Delegated Officer Report Recommendation – Refuse

Application number: UTT/23/0193/FUL
Proposal: Demolition of an industrial unit and erection of 7 no. new industrial units
Site Address: Lovecotes Farm , Chickney Road, Debden, Essex, CM22 6BH
Parish: Debden
Ward: Debden And Wimbish
Applicant: Mr Tony Garllagher
Agent: Ms Anna Charnaux
Target Date: 20th March 2023
Expiry Date: 3rd April 2023
Extension of Time Date: Not Applicable

Lovecotes Farm Chickney Road
Debden Essex, CM22 6BH
New Industrial Units
Proposed Unit 5, 6 Ground,
First and Roof Plan

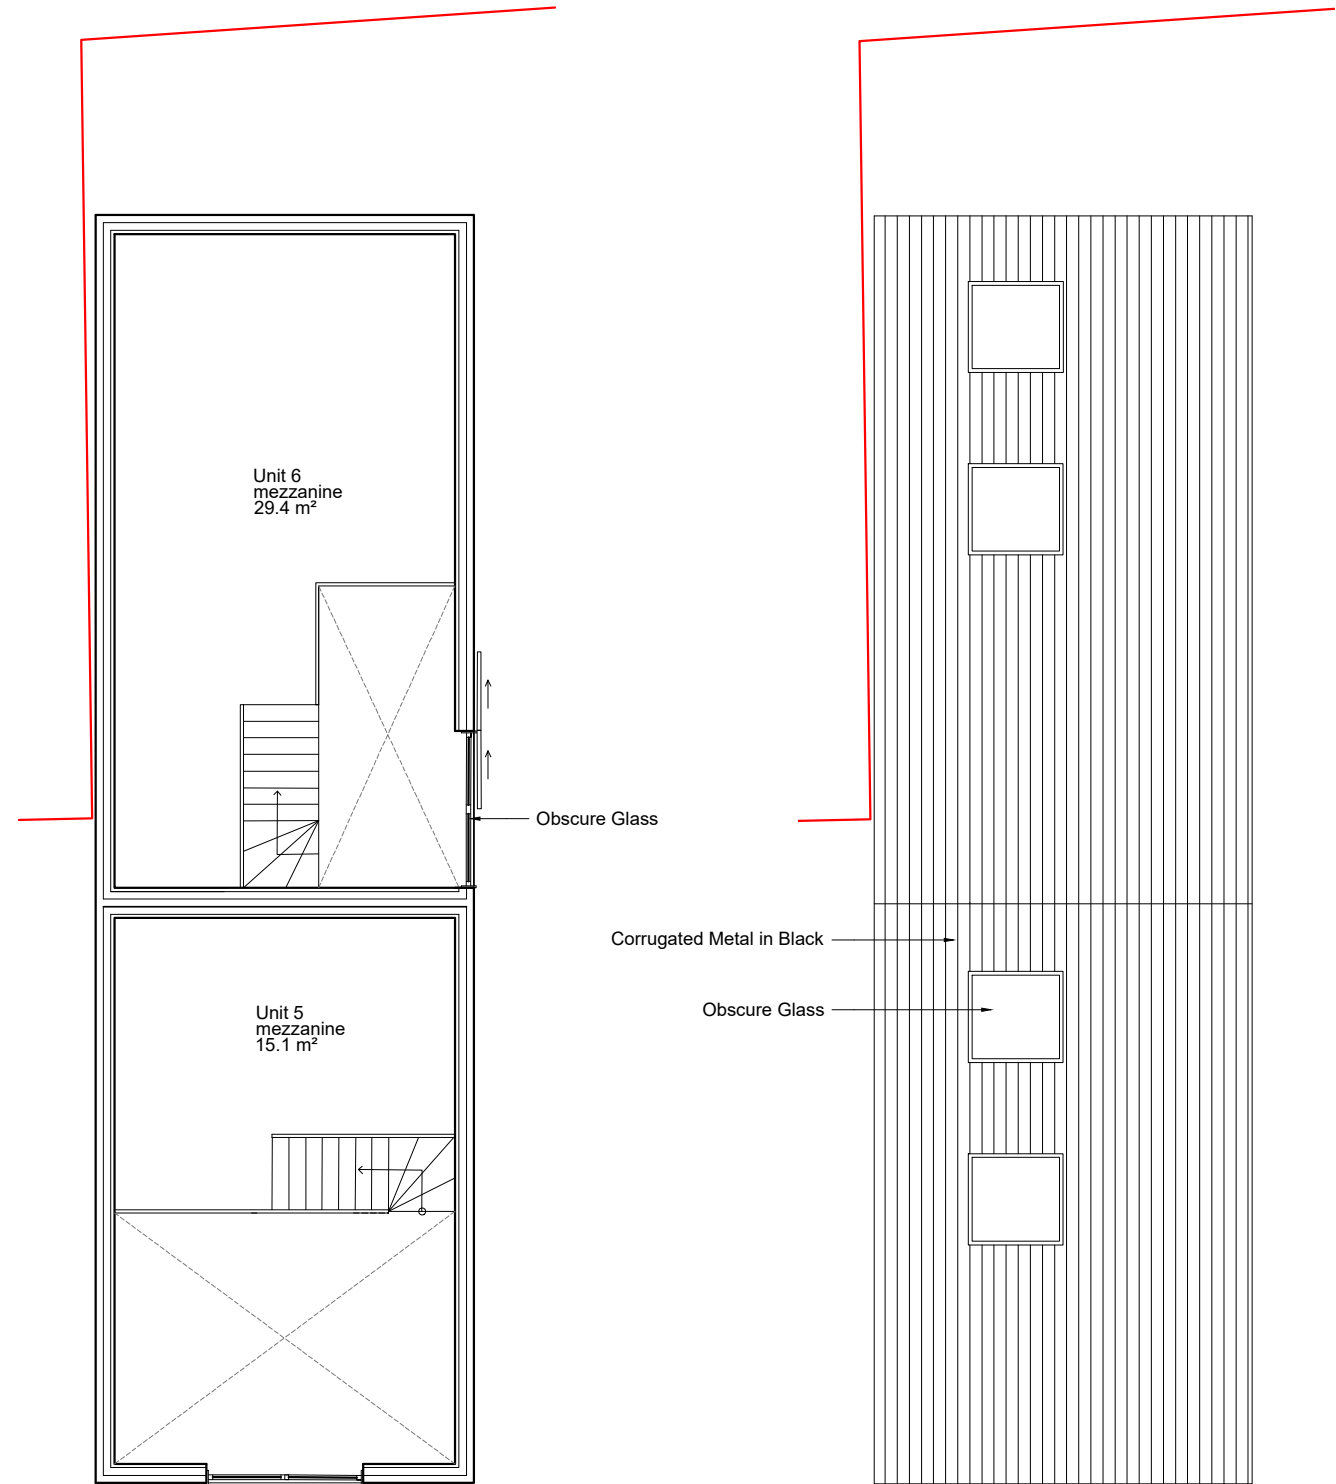
1 By virtue of the size, bulk and massing of the proposals and in particular, buildings 5, 6 and 7, the development would have an adverse impact upon the setting of the Grade II listed building at Lovecotes Farm House. The proposed development is therefore contrary to Policy ENV2 of the Uttlesford Local Plan (2005), Section 66 (1) of the Planning (Listed Buildings and Conservation Areas) Act (1990) and the National Planning Policy Framework (2021).

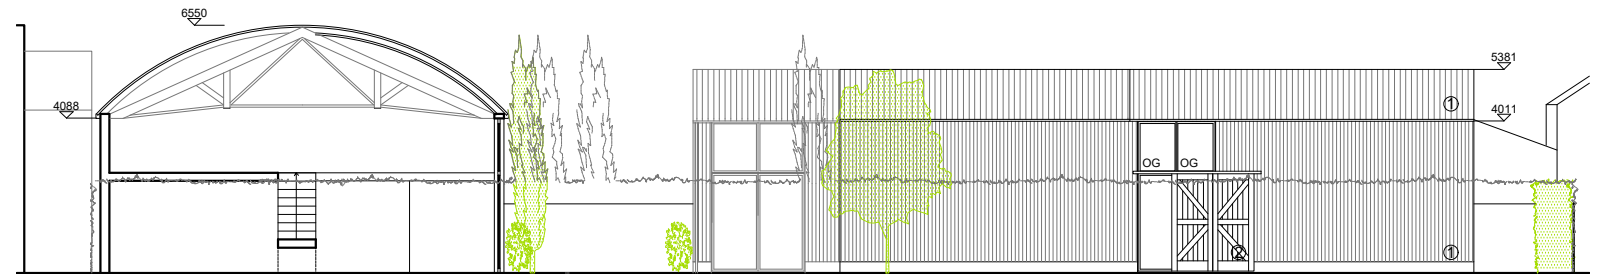
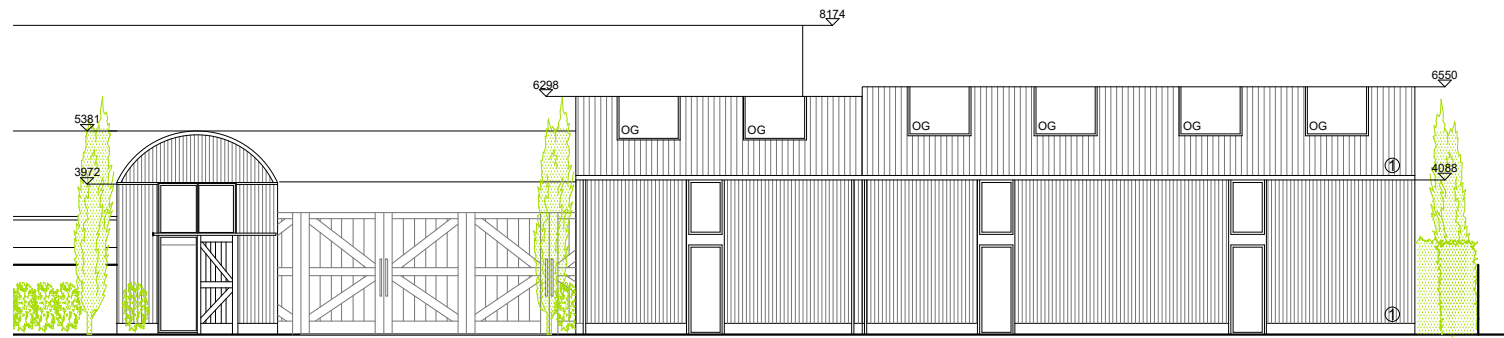
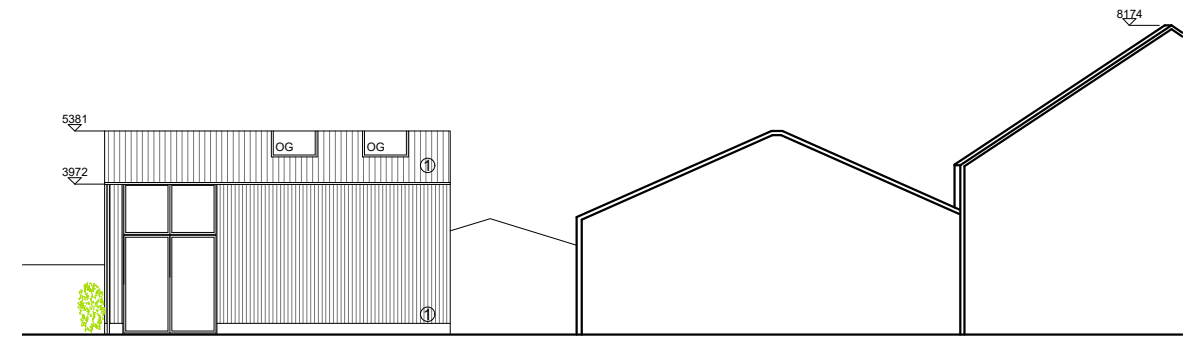
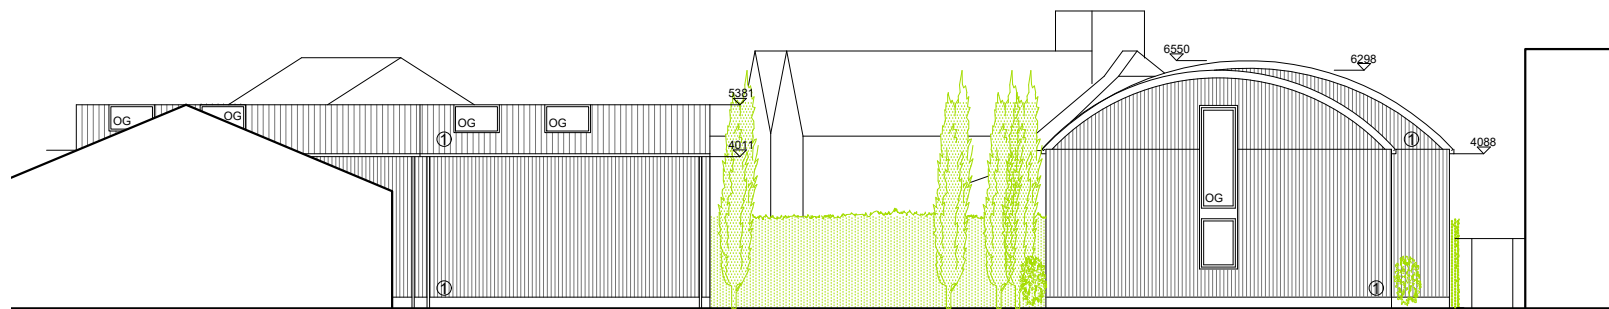
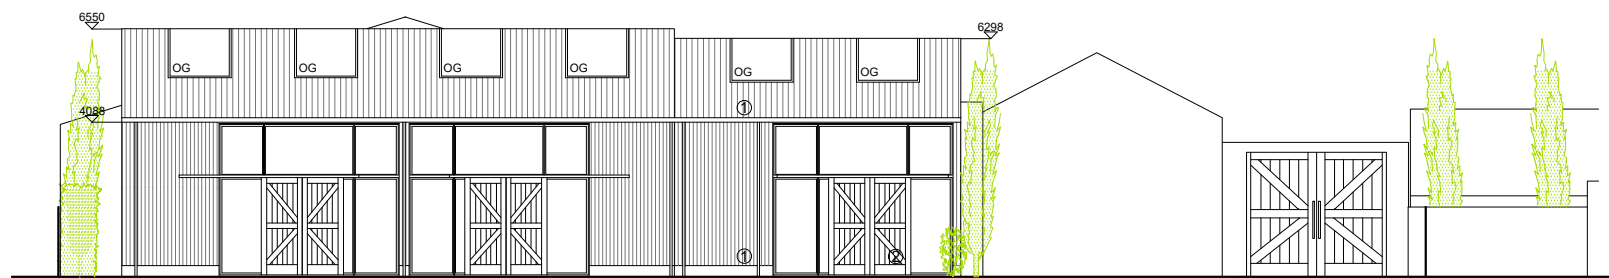
development upon the amenities of the occupier of the neighbouring residential properties would be acceptable in terms of outlook. However, by virtue of the size, bulk and massing of the proposals and in particular, buildings 5, 6 and 7, the development would have an adverse impact upon the setting of the Grade II listed building at Lovecotes Farm House. The proposed development is therefore contrary to Policy ENV2 of the Uttlesford Local Plan (2005), Section 66 (1) of the Planning (Listed Buildings and Conservation Areas) Act (1990) and the National Planning Policy Framework (2021). The use of the proposed buildings is not known and a noise assessment was not submitted with the application and therefore, the potential impacts of the development upon the amenities of the occupiers of those properties are not known. The proposed is therefore contrary to Policy GEN2 of the Uttlesford Local Plan (2005) and the National Planning Policy Framework (2021). The development would provide sufficient parking and sufficient turning space for smaller vehicles, However, it would appear that larger vehicles would have difficulty turning on site due to its layout. In the absence of plans demonstrating so, it is not clear that larger lorries would be able to enter the site and leave it in forwards gear. Lorries reversing onto Chickney Road would represent a hazard to highway safety not only in terms of insufficient visibility for their doing so, but also for their obstructing the road in undertaking such a manoeuvre. The proposed development is therefore contrary to Policies GEN1 and GEN8 of the Uttlesford Local Plan (2005) and the National Planning Policy Framework (2021). The application is accordingly recommended for refusal.

Appendix A

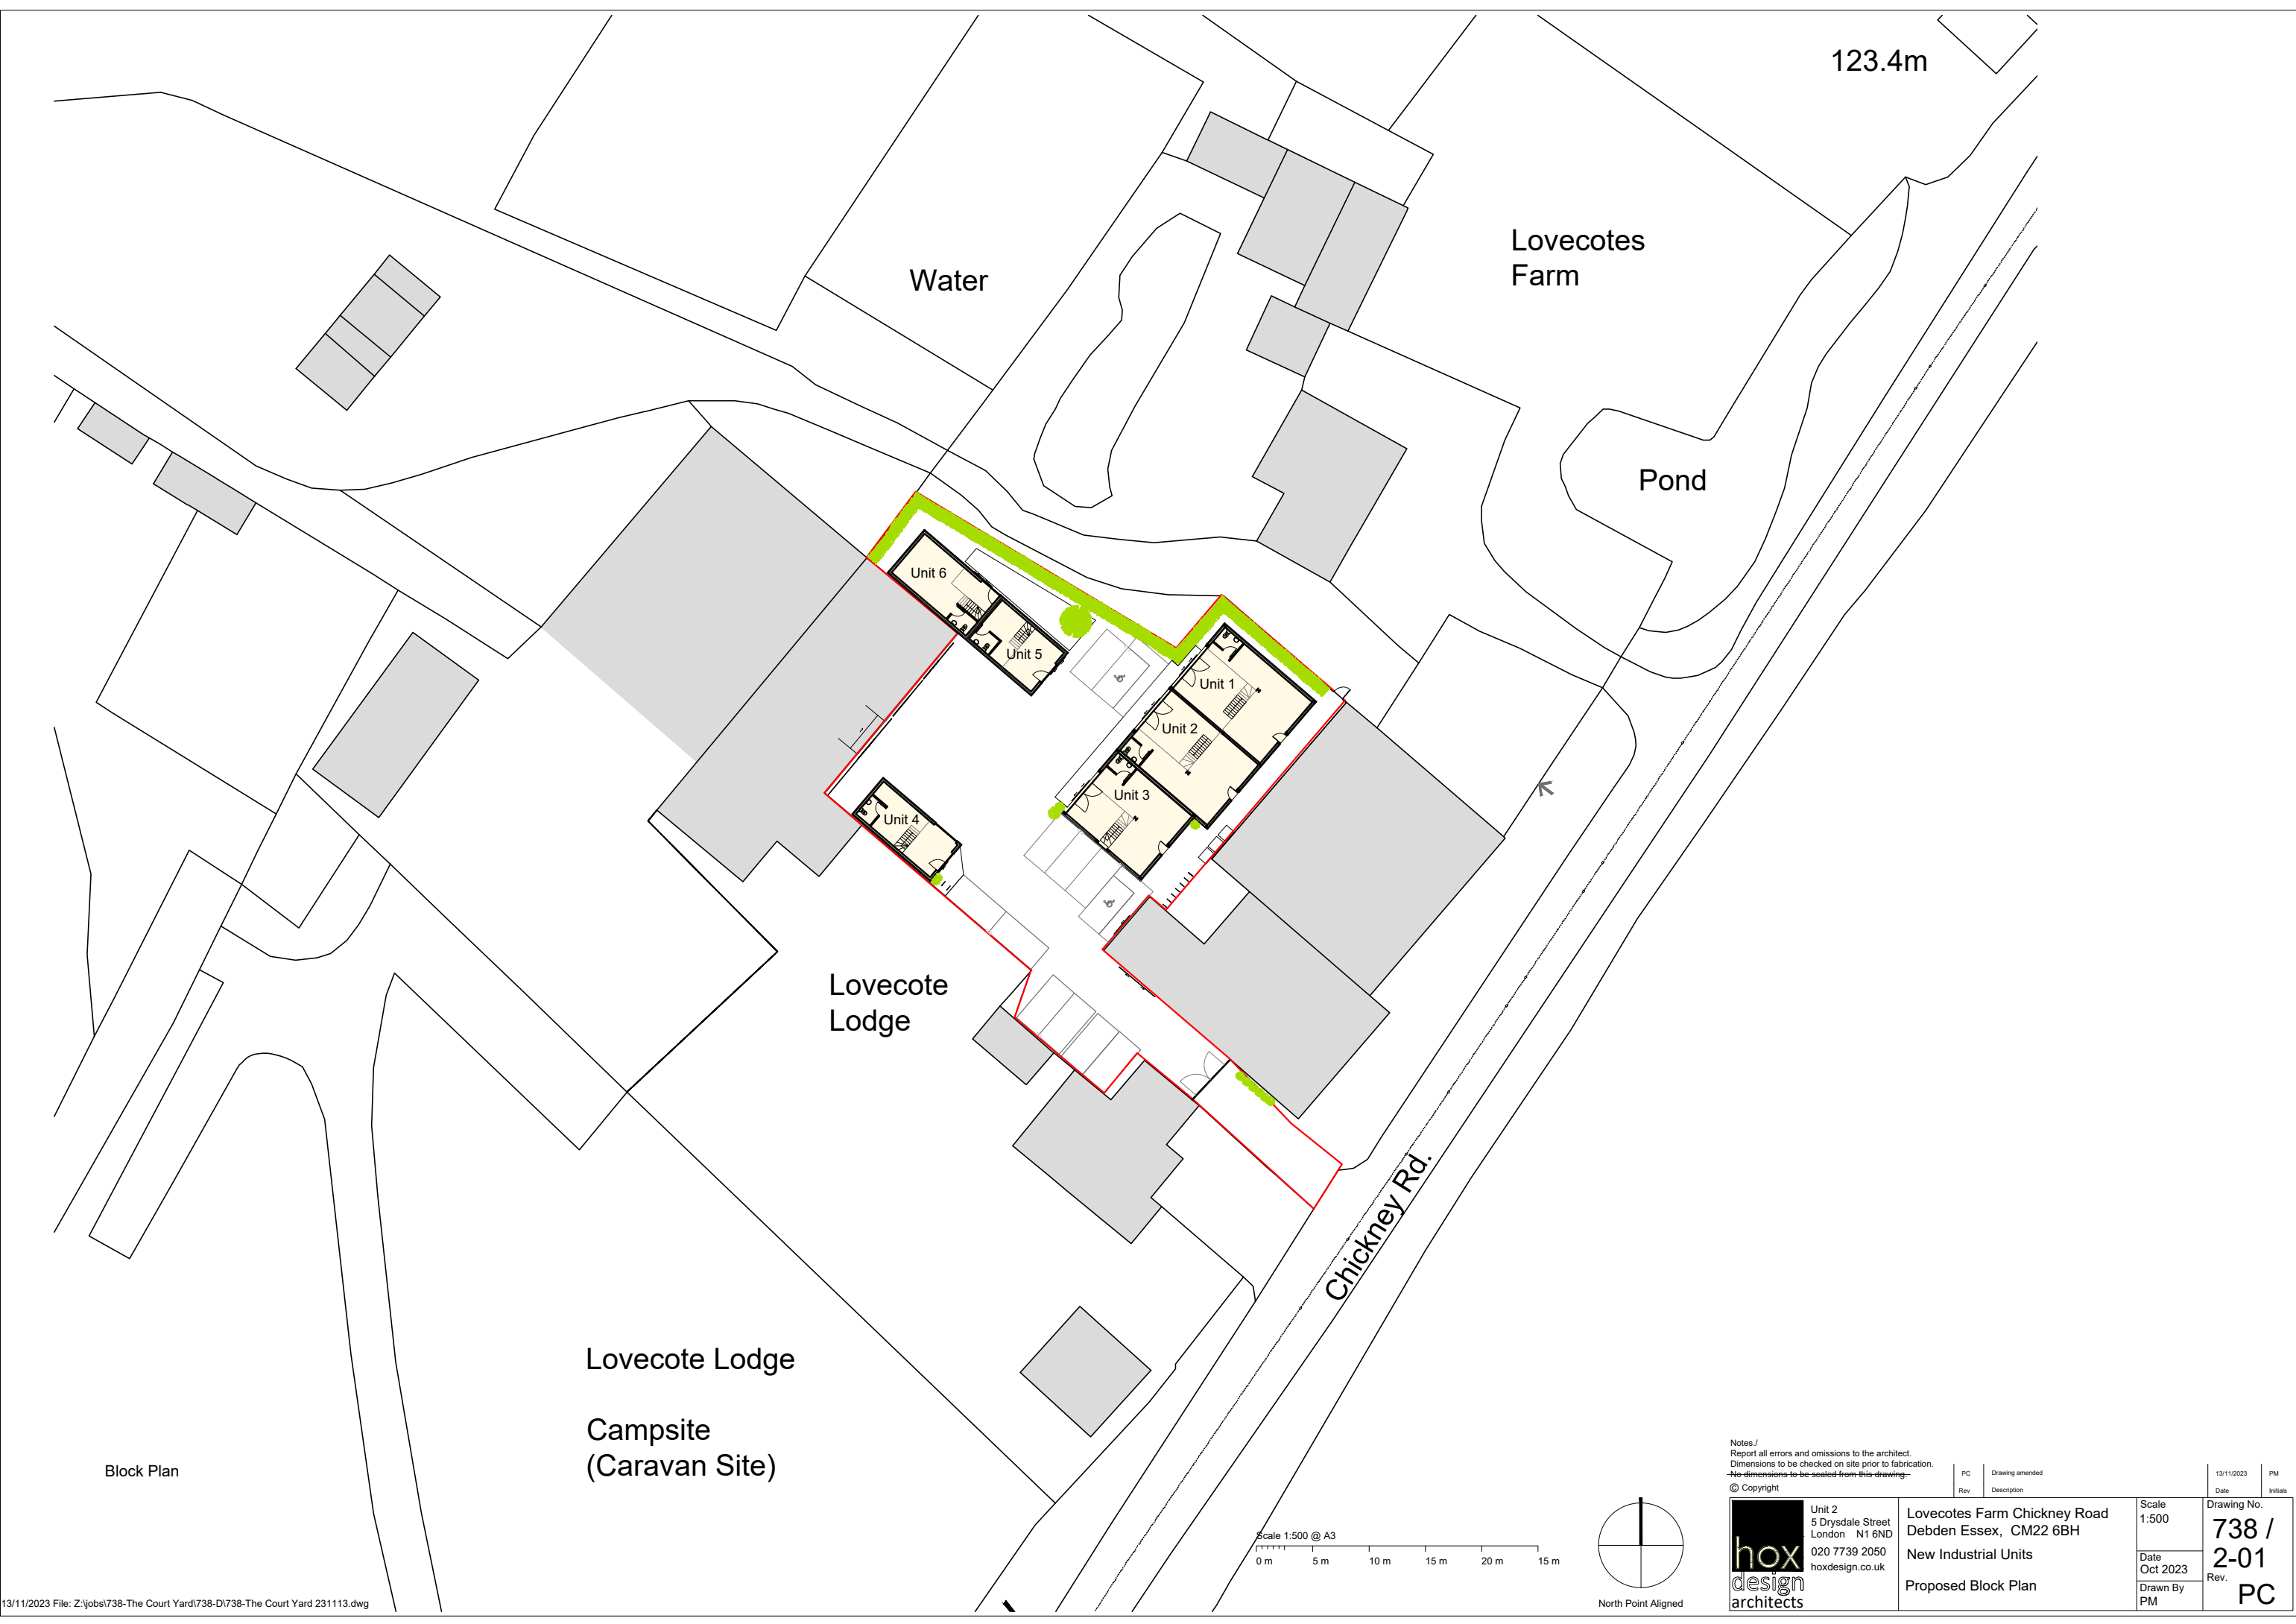
ECC Highways - Would there be sufficient space retained on the site for vehicles to be able to turn to ensure they enter and leave the site in forwards gear, and would there be sufficient parking for all vehicles associated with the site? Further details and plans, including swept path analysis, should be submitted to demonstrate these points.

3 By virtue of the proposed layout of the site and in the absence of plans demonstrating so, it is not clear that larger lorries would be able to enter the site and leave it in forwards gear. Lorries reversing onto Chickney Road would represent a hazard to highway safety not only in terms of insufficient visibility for their doing so, but also for their obstructing the road in undertaking such a manoeuvre. The proposed development is therefore contrary to Policies GEN1 and GEN8 of the Uttlesford Local Plan (2005) and the National Planning Policy Framework (2021).
